**Our Case Number:** ABP-314724-22

**Re:** Railway (Metrolink - Estuary to Charlemont via Dublin Airport) Order [2022]  
Metrolink. Estuary through Swords, Dublin Airport, Ballymun, Glasnevin and City Centre to  
Charlemont, Co. Dublin

## Observation on a Strategic Infrastructure Development Application

ST. STEPHENS GREEN STATION

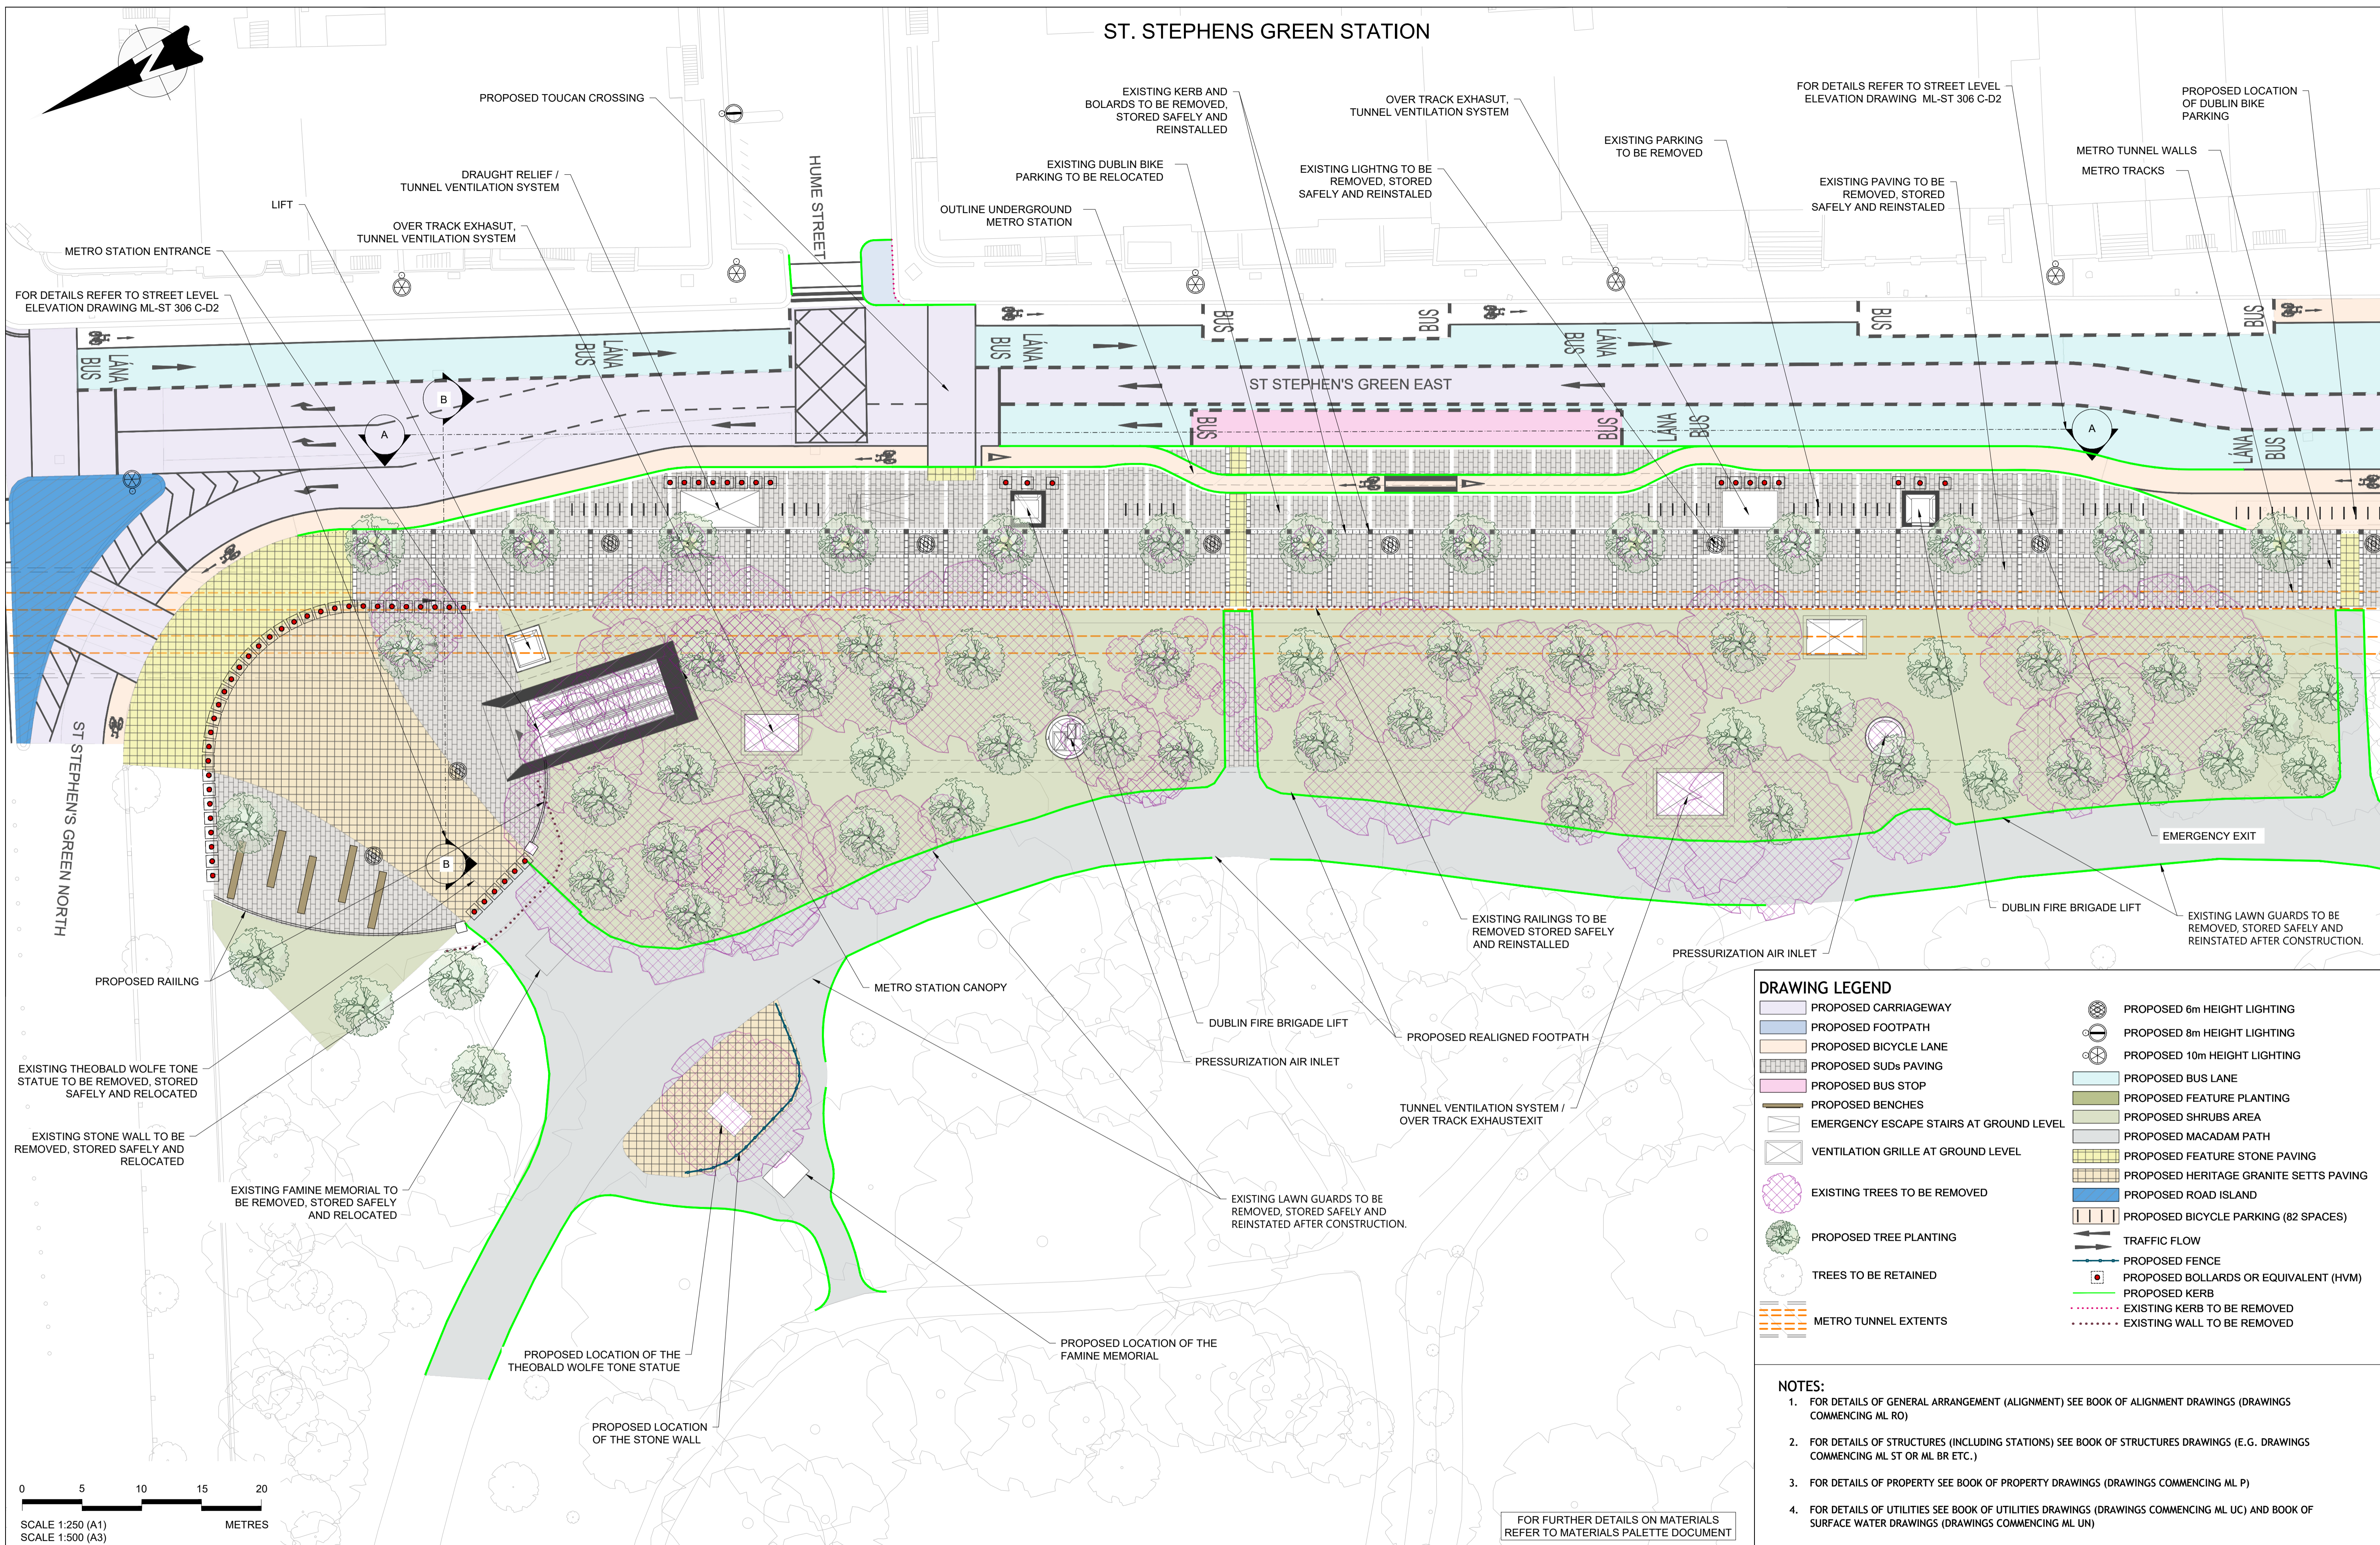
I would like to make an observation regarding the siting of the St. Stephens Green Station: namely the cut and cover works for the station location, as the project does not seem to have balanced the full range of factors that should have been taken into account. Certain pragmatic criteria have been more heavily weighted than concerns for the damage to a fine public realm and park. It appears as if the inevitable construction phase difficulties and services diversion required in siting it entirely in the existing road St Stephens Green East have made the park a softer option. The absence of good cross sections across this road is a deficiency in the application. It is troubling that any part of Dublin's best loved park could ever be considered as suitable for a major cut and cover project for the station while alongside lies an adjacent wide roadway (St. Stephens Green East) with capacity for the station, its entrances and structures, allowing for a successful and complete re-instatement after the works. I will confine the argument to the following points:

There is really nothing convincing in its proposed re-located position, rendered impotent of function and pushed back out of the way, while the station entrance, (I can't decide if it is apologetic or assertive as depicted), is just one of a series of new shaft elements that will clutter this side of the park. This process of eroding the integrity of what is already a good place by not considering its merits sufficiently means that adding new elements or siting them (the station designs seem to drive the same functional elements that extrude above ground) results in these clumsy outcomes.

Focusing on re-instatement of elements as they were before, (just a jiggle this way or that to make them fit around the new things) can never do that job adequately in this setting. Once the concept is lost through the modifications necessary to make the new proposals work, it is gone forever. There is a question if this piece of public realm excellence is fully understood in its complexity, this corner is a landmark, despite its sobriety and sense of calm, it skilfully resolves a new intervention (1964) in an existing historic setting in a manner that one hardly notices. Indeed, it might have served as a lesson to the more reflective members of the Metrolink design team as to working in a historic context. But if it's not recognized as such, then the other arguments around inconvenience and cost win out and the matter becomes settled for the wrong reasons.

The overriding outcome is another diminution of an original concept of wholeness and a fragmentation of the concept behind it. Unlike the planting which is entirely another matter, the juxtaposition of the new permanent and visible project elements such as the entrances, shafts, lifts etc. tip the balance in the wrong way. Here they clutter, push more important things aside or remove them and results in a random placement and juxtaposition of new and old. In the northern and suburban parts of this scheme many of these elements, (such as well-designed entrances and considered landscape design) can improve an area and in Metrolink many do so positively. However, a special place like this is a much more difficult task, perhaps requiring more engineering ingenuity in managing the visible parts above ground and at the same time a modesty of expression if it is not to harm the space's already established attributes.

The felling of trees for such projects is usually understated and in a “cut and cover” project, there are overhanging branches and adjoining roots of retained trees impacted so the neat little box is rarely the actual damage zone. Changes to hydrology locally can be detrimental to mature trees. The imbalance to the composition of the canopy within the park will be a very damaging outcome, it will be an obvious visual and ecological negative and one that can only recover over generations.

While allowing for soil build up over the station and re-planting generously, (assuming that there won't be design constraints for loading at the detailed design stages that begin to erode that proposition) it will never be as good. A re-instatement is not always a successful replacement for the status quo. Who can set a price on the value of a sewer diversion (that we are told is a significant part of not using the carriageway as the station cut and cover site) that would leave the park intact and allow the status quo to prevail after the works? We really need to show what we value in Dublin.
